From: Contact Centre (CRM) <contact@ribblevalley.gov.uk>
Sent: 14 May 2023 18:16
To: Planning
Subject: Planning Application Comments - 3/2023/0092 FS-Case-515693785

Planning Application Reference No.: 3/2023/0092

Address of Development: Unit 2 53 to 55 Berry Lane Longridge PR3 3NH

title
Proposed
External Elevations

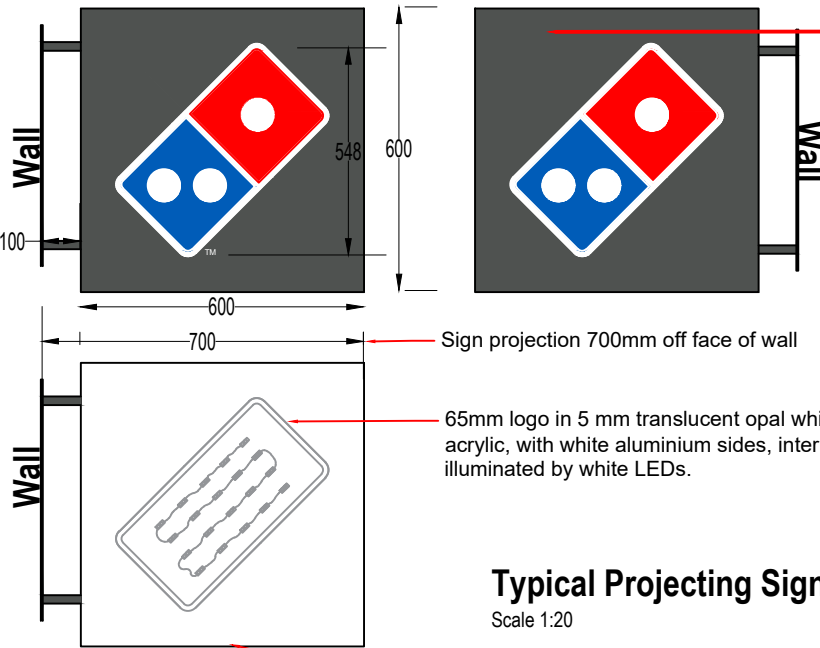
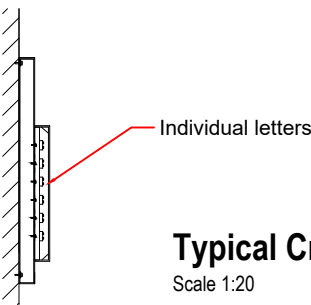
Comments: The application states internal/back lighted signs and a digital screen, according to "communities and local government Outdoor advertisements and signs: a guide for advertisers" as found on the RVBC website, neither of these are aloud in Longridge
